Application No: AW/35/22/HH
Site Address: 49 The Drive Aldwick PO21 4DS
Description of works: Erection of single storey rear extension and conversion of loft to habitable use following the demolition of existing rear conservatory.

Thank you for your internet representation made on 25th March 2022 which has been recorded as an objection with the comments as follows:

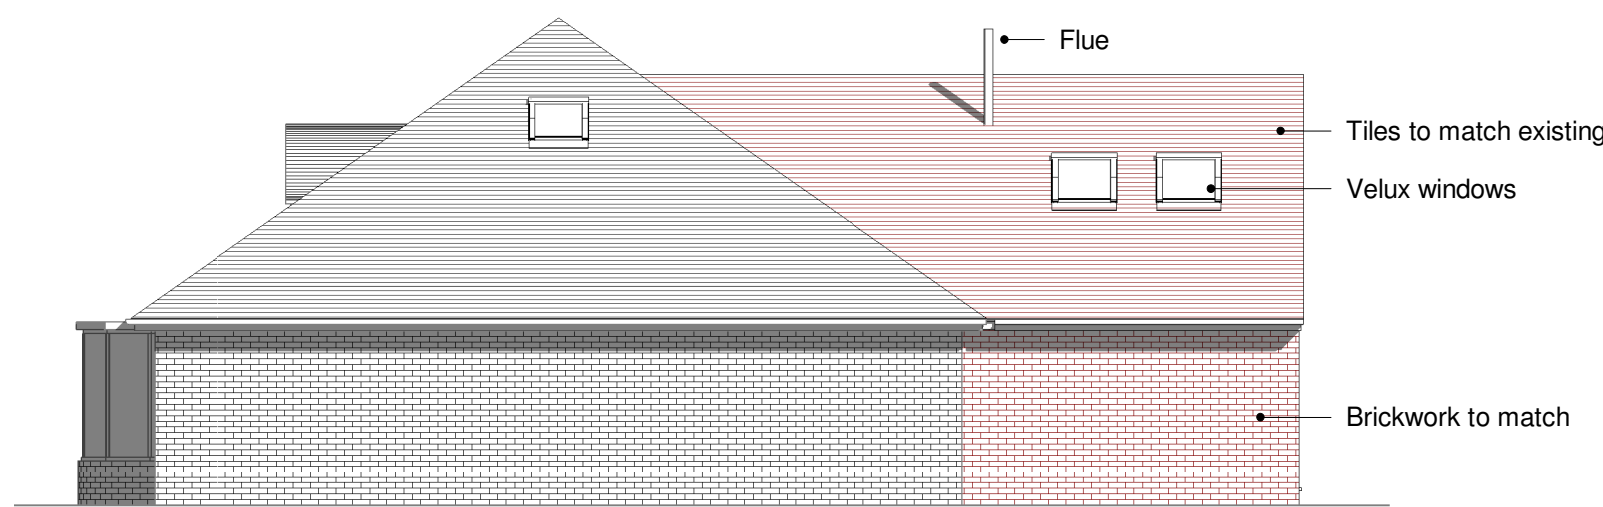
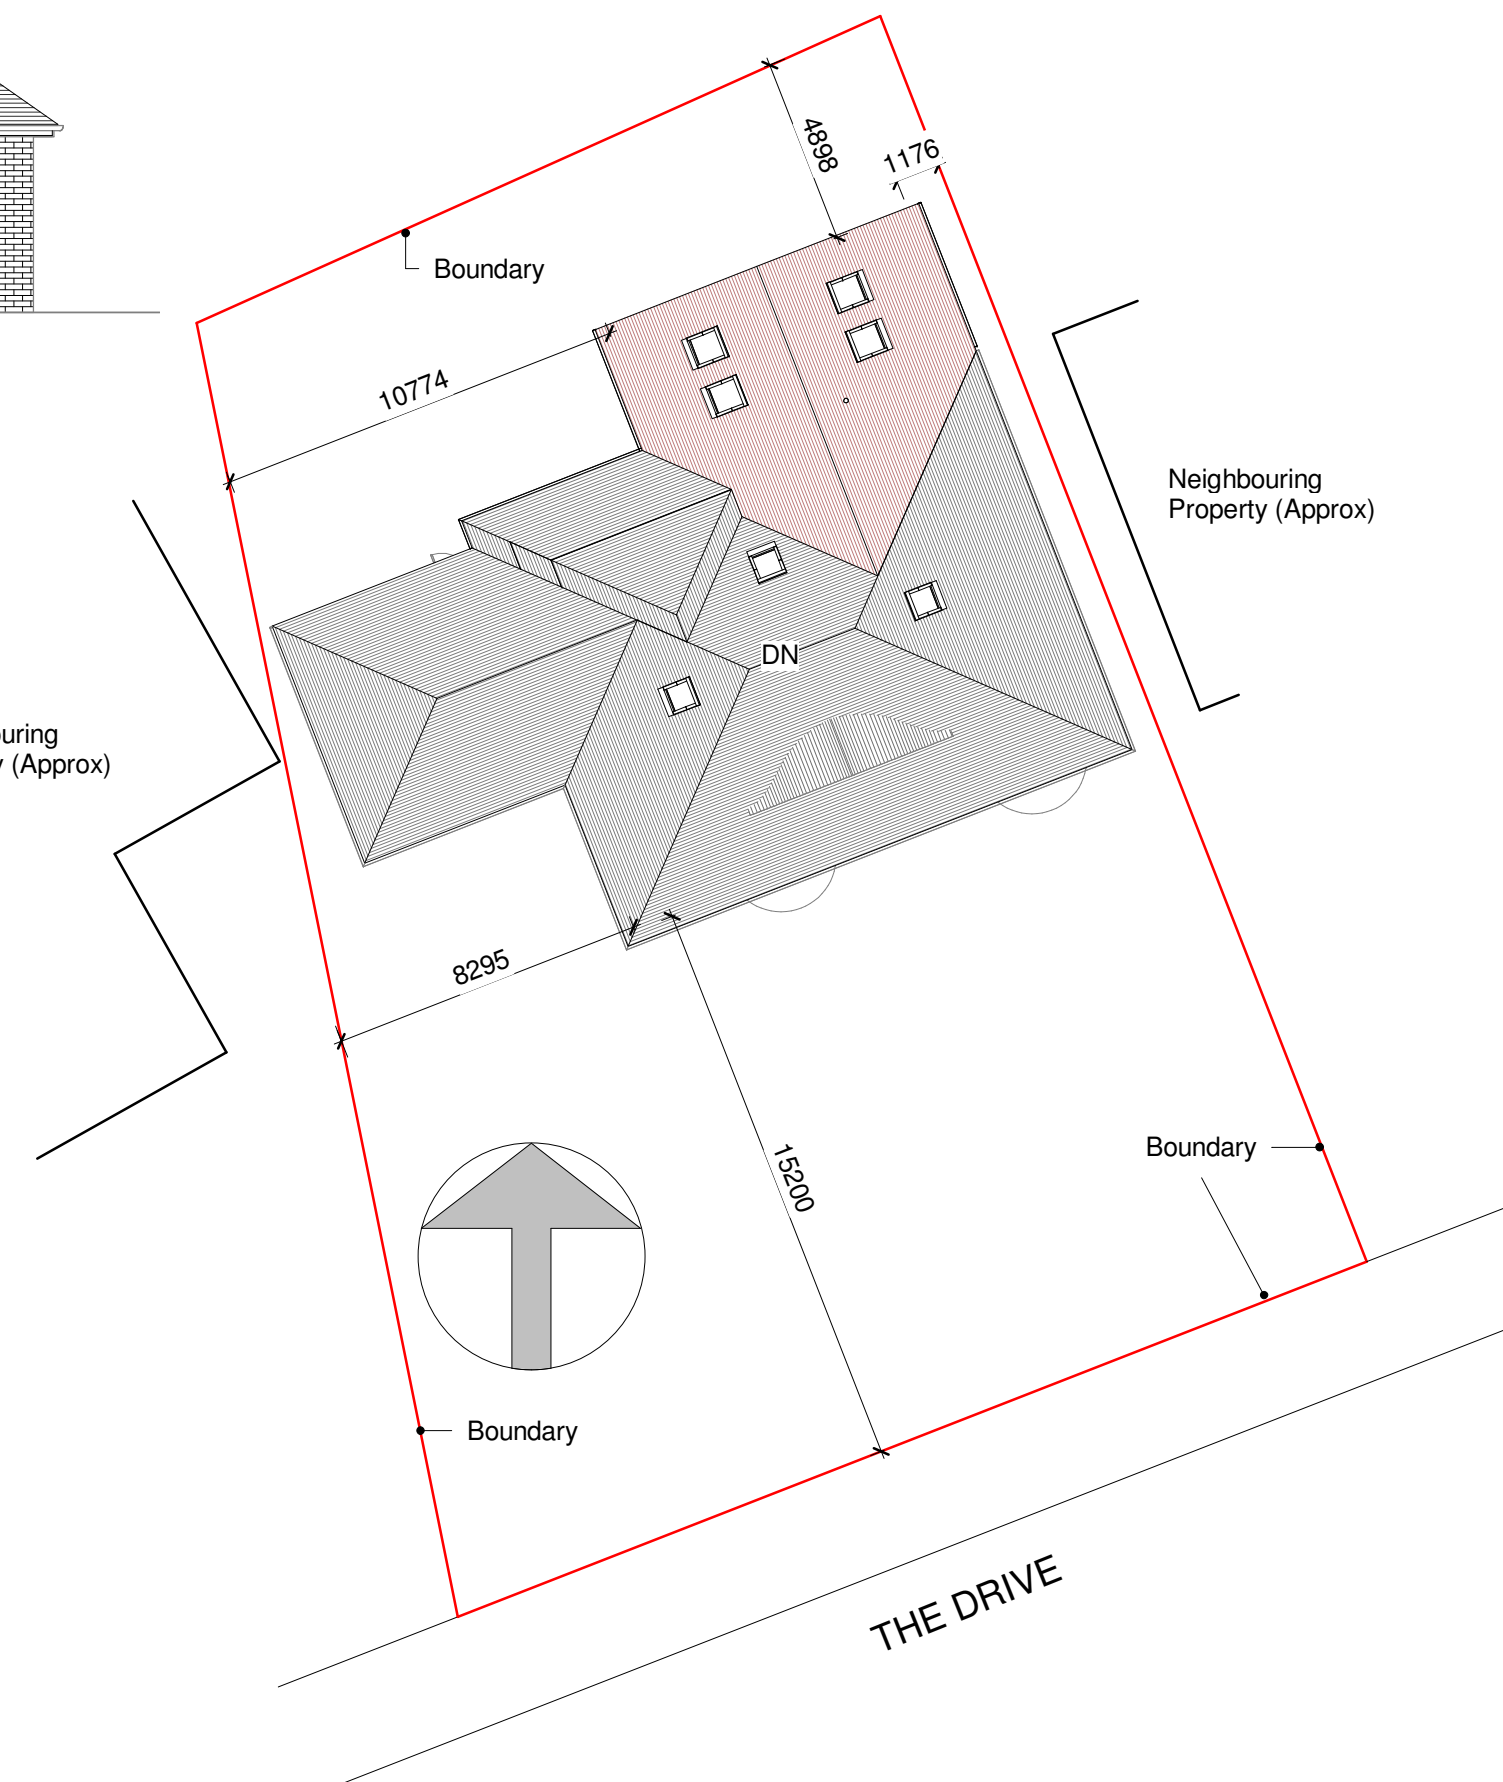
Given that the proposed conversion of loft to living space will result in direct line of sight from the new room into my bedroom at an alarmingly close distance, where there is currently no over-looking I feel I have to object.
